One Earth Solar Farm

Draft Statement of Common Ground with West Lindsey District Council

EN010159/APP/8.4.4

December 2025

- Order Limits
- 2km LVIA Study Area
- District Boundary
- Representative Viewpoint

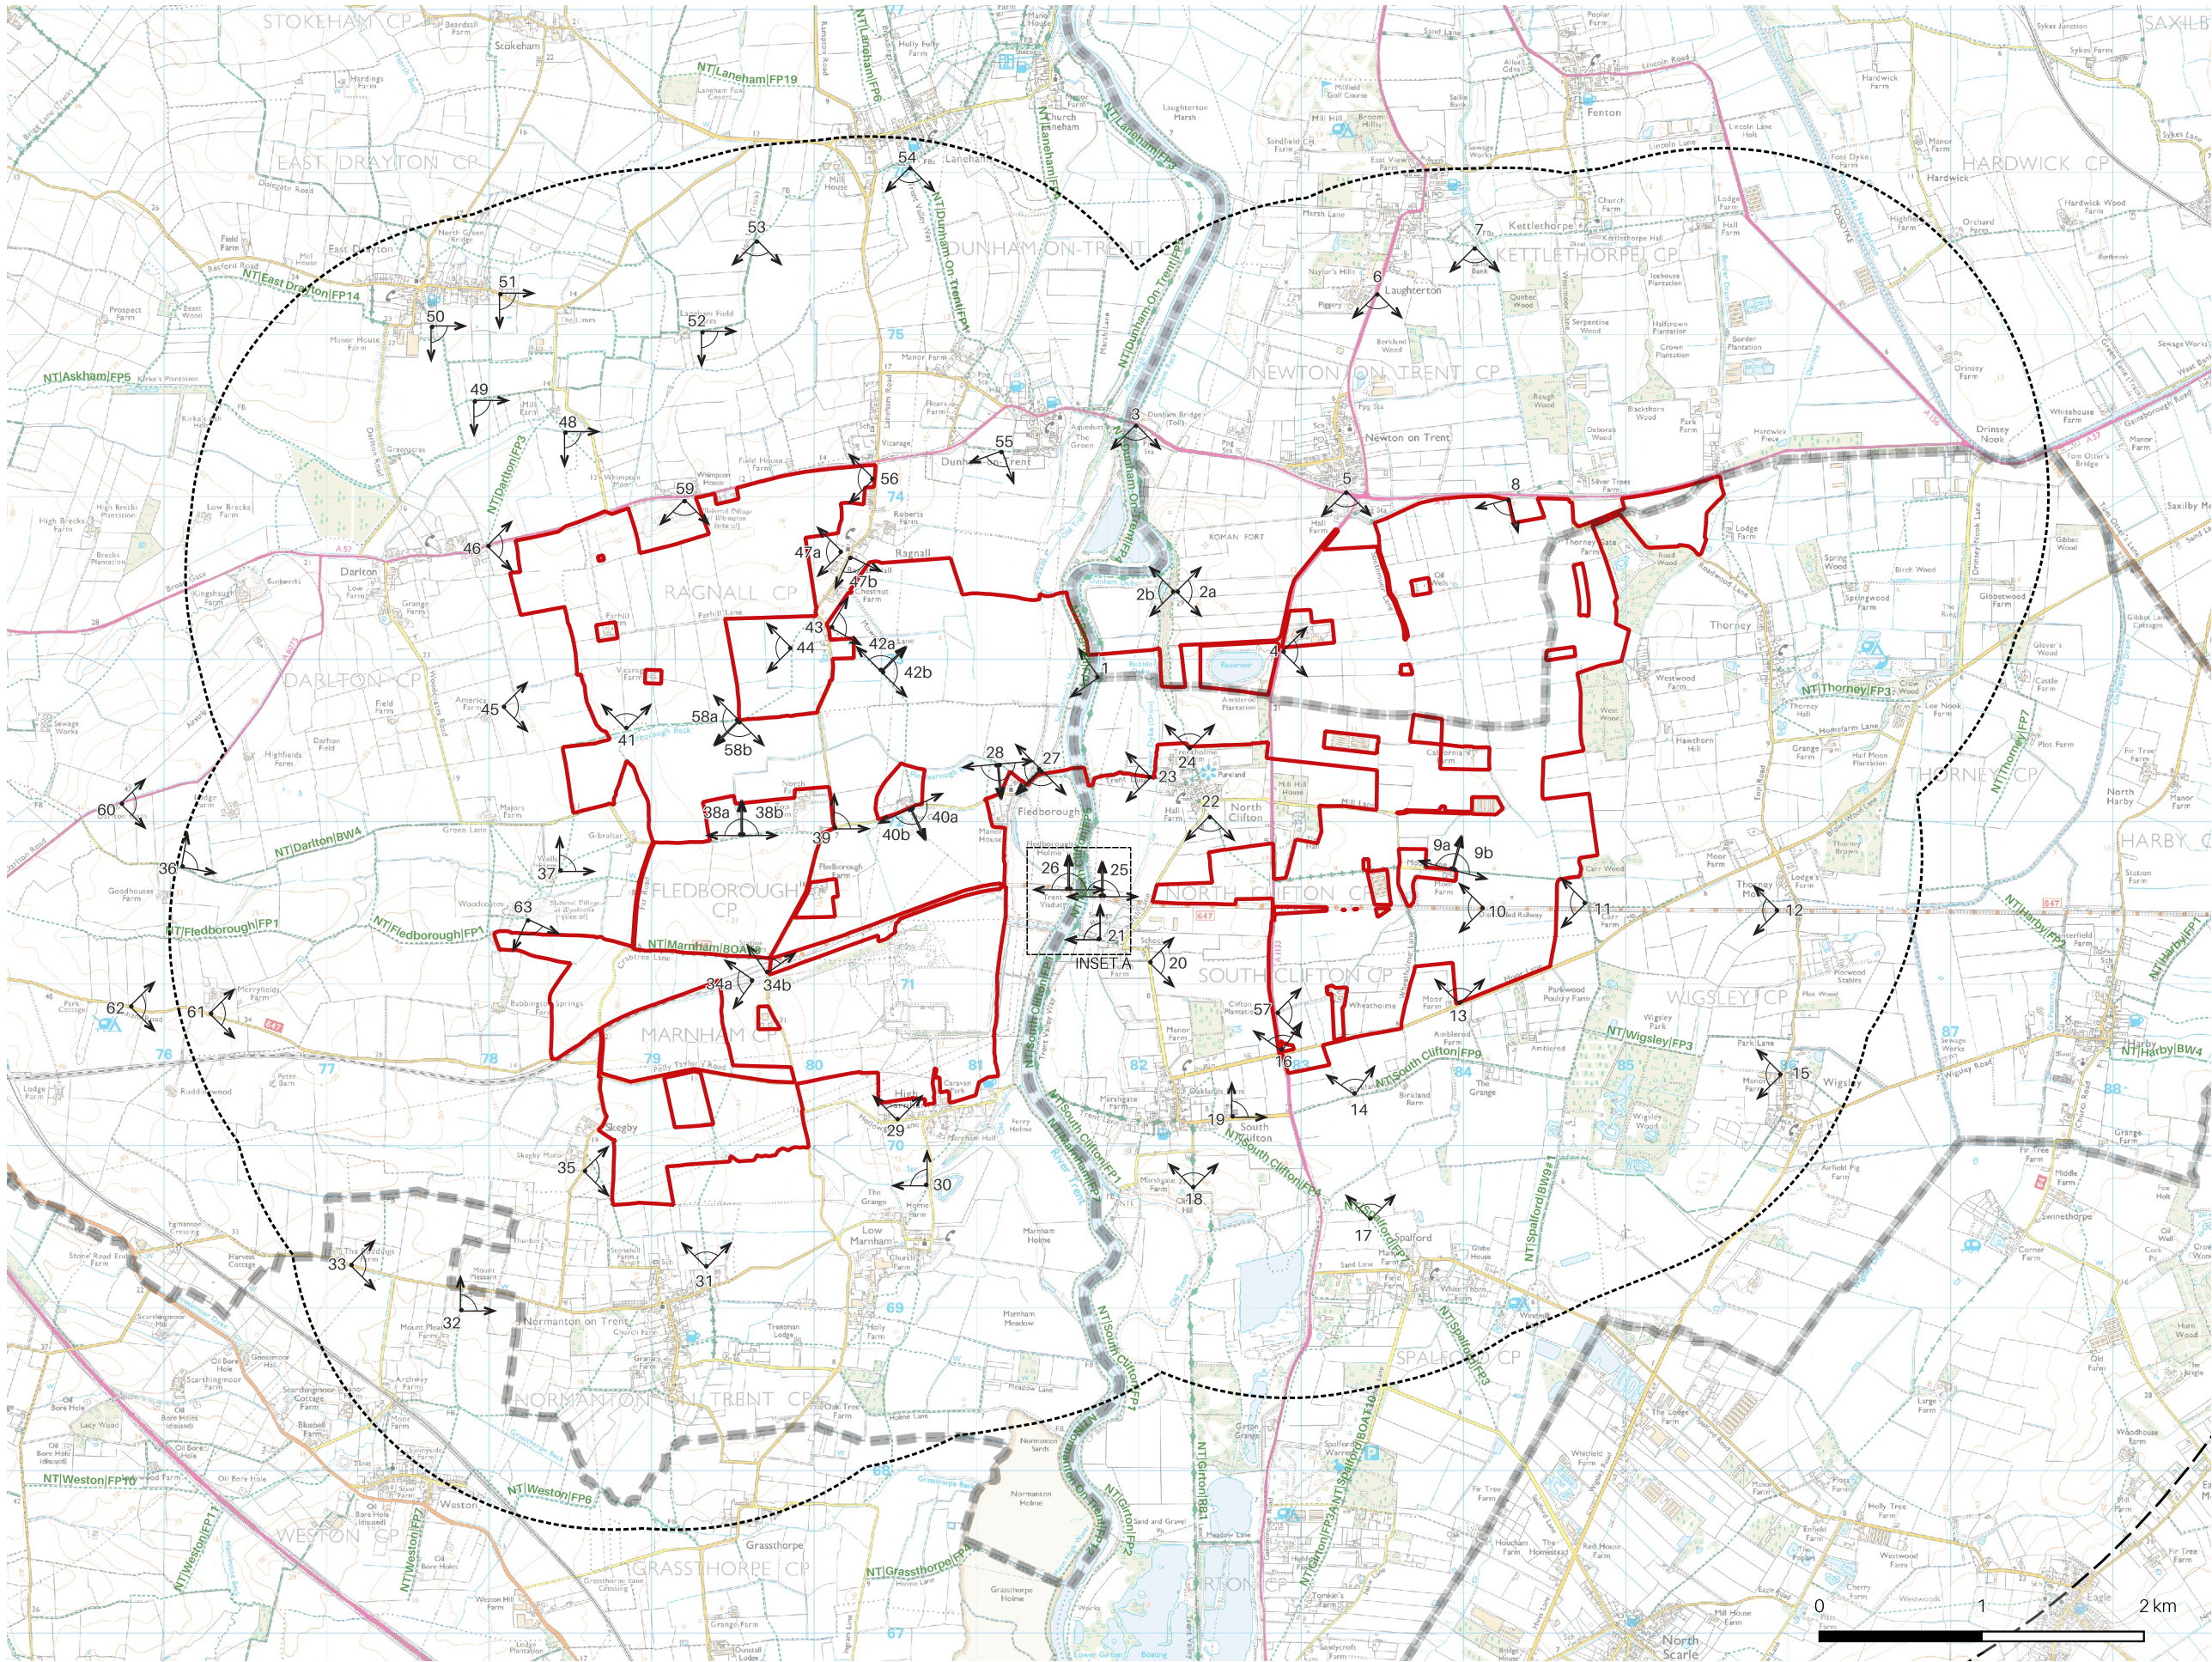
| 04-05 | Scope of representative viewpoints | <p>West Lindsey District Council would request that a representative viewpoint is included from the layby on the A1133 (53°14'36.0"N 0°45'37.5"W) (What3Words Monkeys.stunner.newlywed). We agree this will be supplementary to the existing assessment.</p> <p>WLDC welcome the production of a verified view which was tabled at a meeting regarding this SoCG.</p> <p>WLDC consider that this verified view should be submitted into examination as it provides a helpful context to understanding the potential visual impacts associated with each of the two substation options the applicant has identified. In particular the verified view demonstrates the horizon line</p> | <p>The Applicant has provided a baseline photograph from the suggested location at Deadline 5.</p> <p>This was agreed to be supplementary to the existing assessment of motorists along the A1133, rather than requiring further assessment.</p> <p>The locations and number of viewpoints was agreed during the pre-application process. Subsequently an additional viewpoint photograph was requested from the A1133 which has now been provided.</p> <p>No response for an additional photomontage was received from WLDC until 01/12/2025. The photomontage showing the proposed development from viewpoint 4 [REP2-031] was prepared to show views from</p> | Not Agreed |
